**STORMWATER MANAGEMENT PLAN CHECKLIST**

**Skyline at Lorson Ranch**

Revised: July 2019

**SKYLINE AT LORSON RANCH AND
 OVERLOT EARLY GRADING AND
 EROSION CONTROL PLAN**

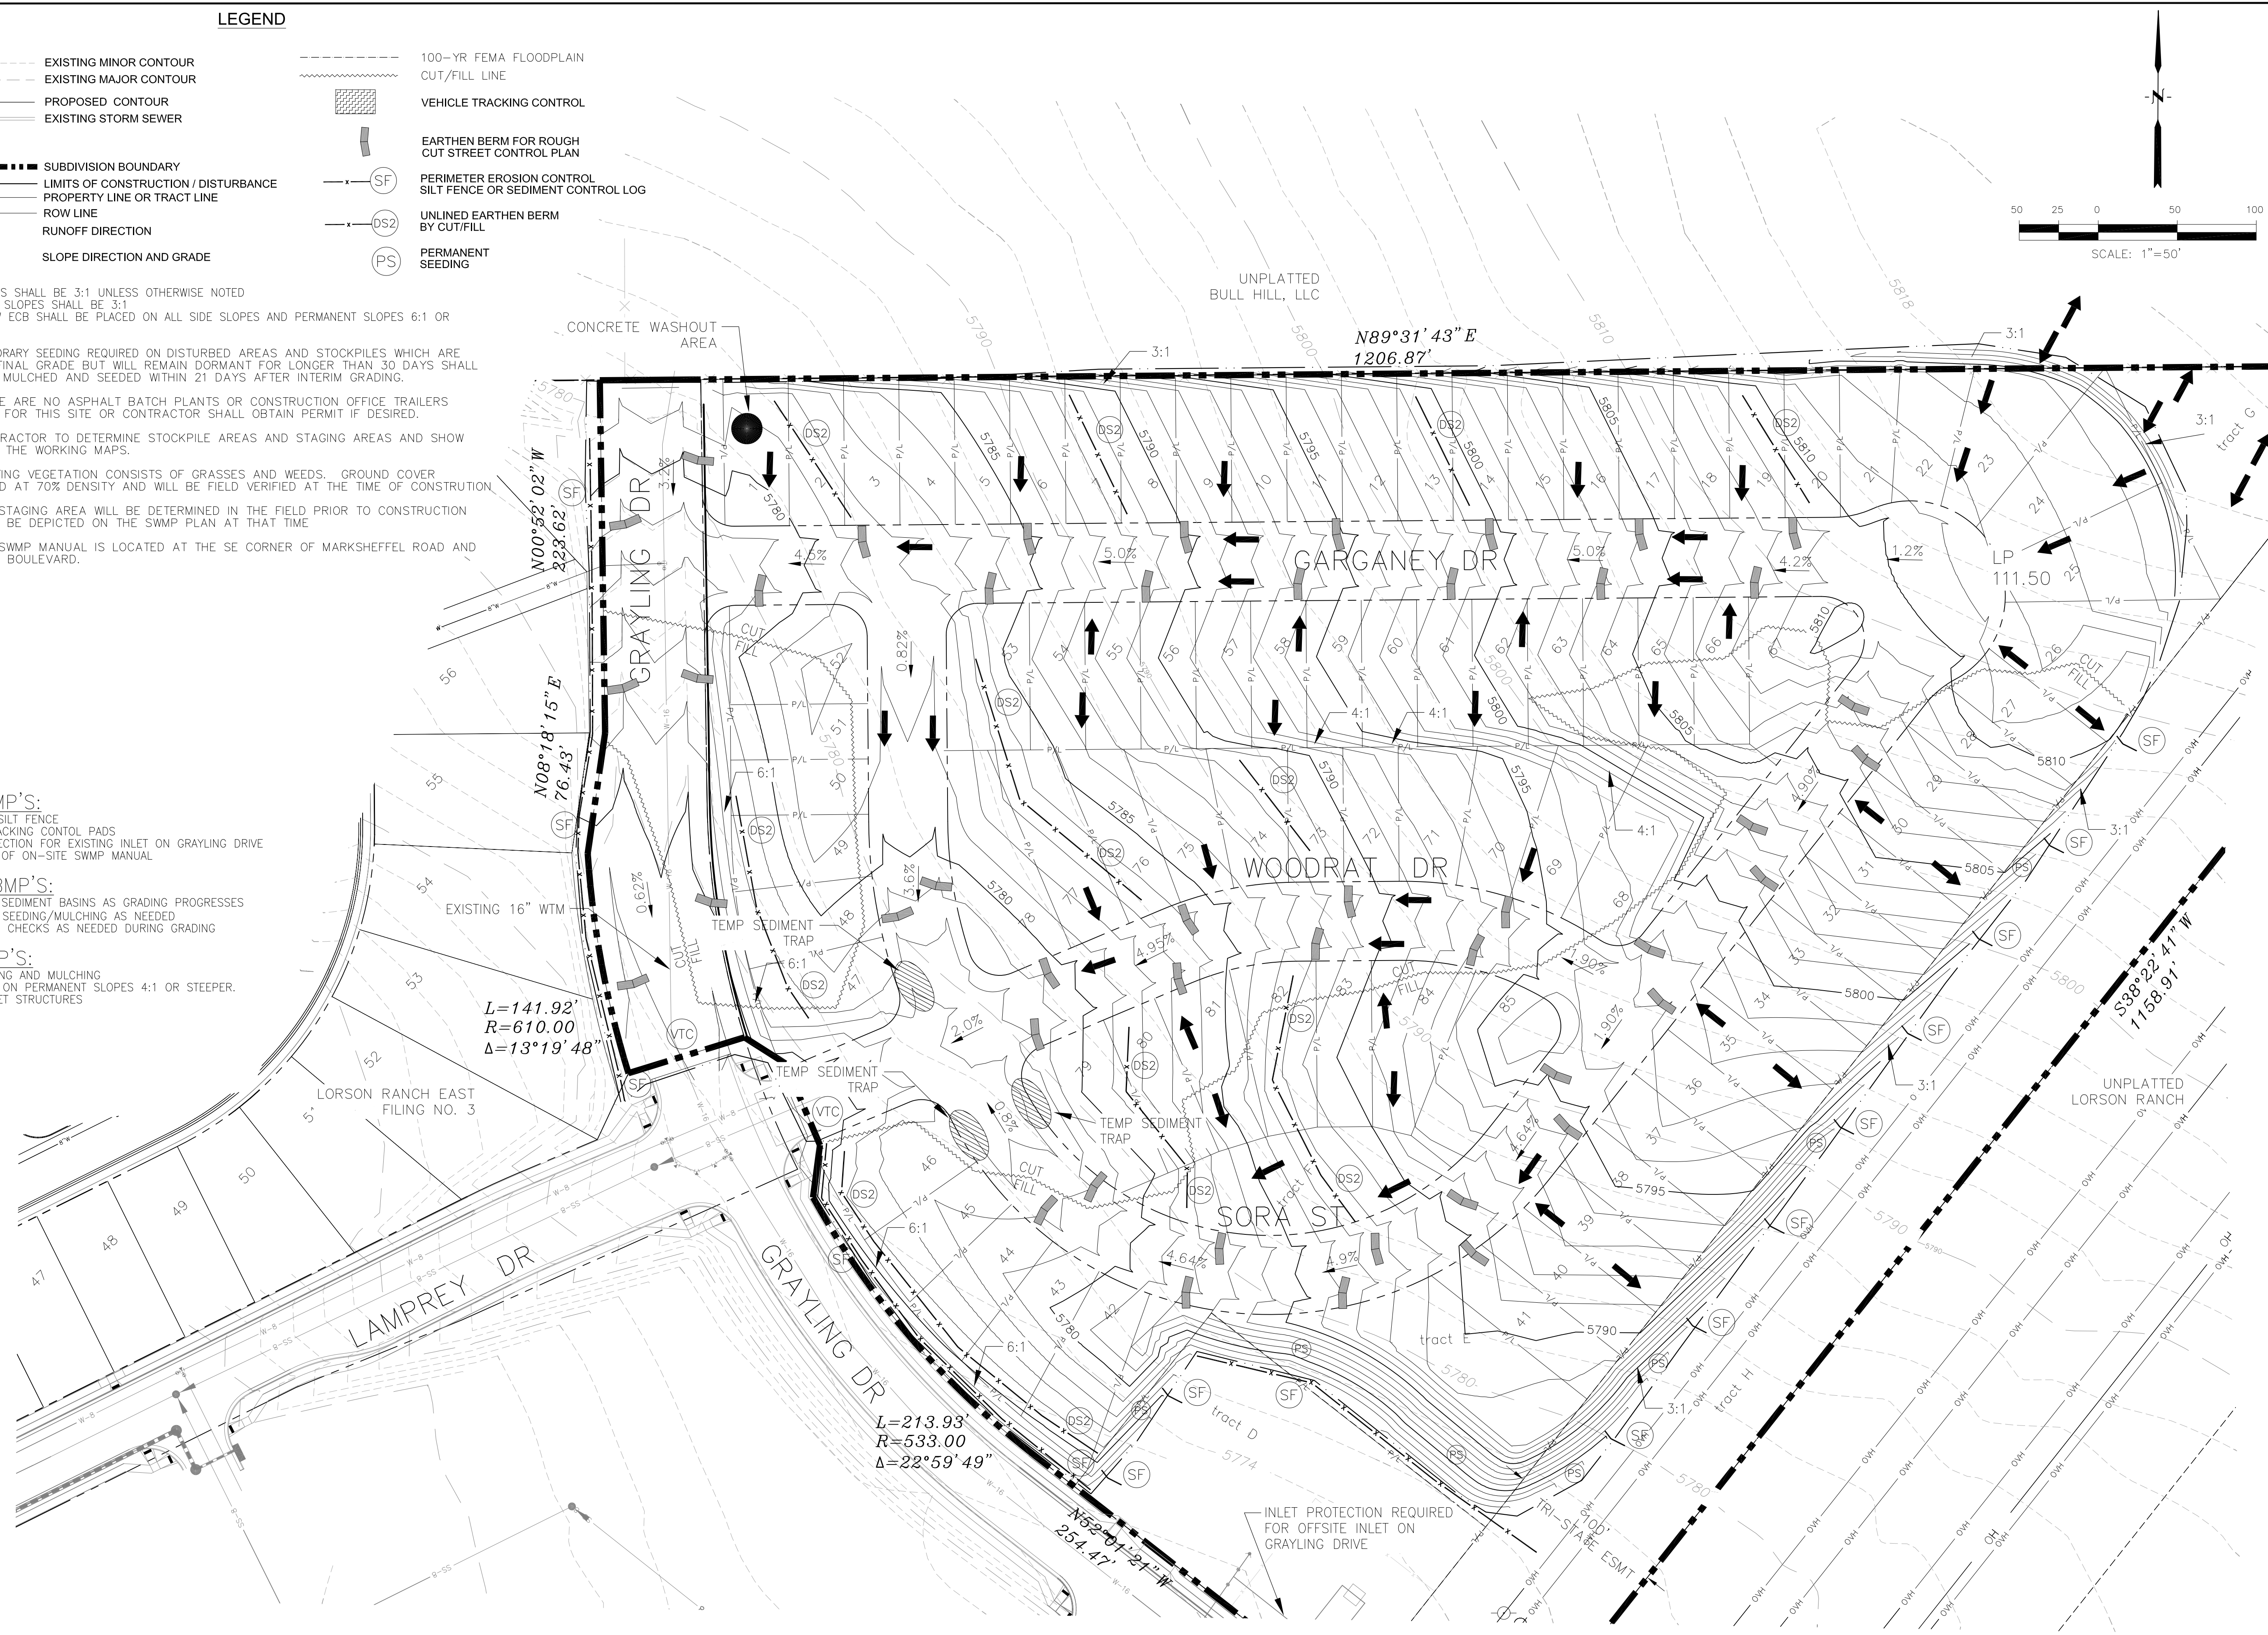
Applicant	PCD
17	SWMP Map to include:		
17a	construction site boundaries	y	✓
17b	flow arrows to depict stormwater flow directions	y	X
17c	all areas of disturbance	y	✓
17d	areas of cut and fill	y	✓
17e	areas used for storage of building materials, soils (stockpiles) or wastes	y	✓
17f	location of any dedicated asphalt / concrete batch plants (No batch plants on-site)	Y	✓
17g	location of all structural control measures	Y	✓
17h	location of all non-structural control measures	Y	✓
17i	springs, streams, wetlands and other surface waters, including areas that require maintenance of pre-existing vegetation within 50 feet of a receiving water (No areas require maintenance of pre-existing vegetation)	Y	✓
18	Narrative description of all structural control measures to be used. Modifications to EPC standard control measures must meet or exceed County-approved details.	y	X
19	Description of all non-structural control measures to be used including seeding, mulching, protection of existing vegetation, site watering, sod placement, etc.	y	✓

20	Technical drawing details for all control measure installation and maintenance; custom or other jurisdiction's details used must meet or exceed EPC standards	y	X
21	Procedure describing how the SWMP is to be revised	y	✓
22	Description of Final Stabilization and Long-term Stormwater Quality (describe nonstructural and structural measures to control SW pollutants after construction operations have been completed, including detention, water quality control measure etc.)	y	✓
23	Specification that final vegetative cover density is to be 70% of pre-disturbed levels	y	✓
24	Outline of permit holder inspection procedures to install, maintain, and effectively operate control measures to manage erosion and sediment	y	✓
25	Record keeping procedures identified to include signature on inspection logs and location of SWMP records on-site	y	✓
26	If this project relies on control measures owned or operated by another entity, a documented agreement must be included in the SWMP that identifies location, installation and design specifications, and maintenance requirements and responsibility of the control measure(s).	y	✓

<b>Please note: all items above must be addressed. If not applicable, explain why, simply identifying "not applicable" will not satisfy CDPHE requirement of explanation.</b>		
<b>2. ADDITIONAL REPORTS/PERMITS/DOCUMENTS</b>			
a	Grading and Erosion Control Plan (signed)	no	
b	Erosion and Stormwater Quality Control Permit (ESQCP) (signed)	y	
<b>3. Applicant Comments:</b>			
a	Plan will be signed on next submittal
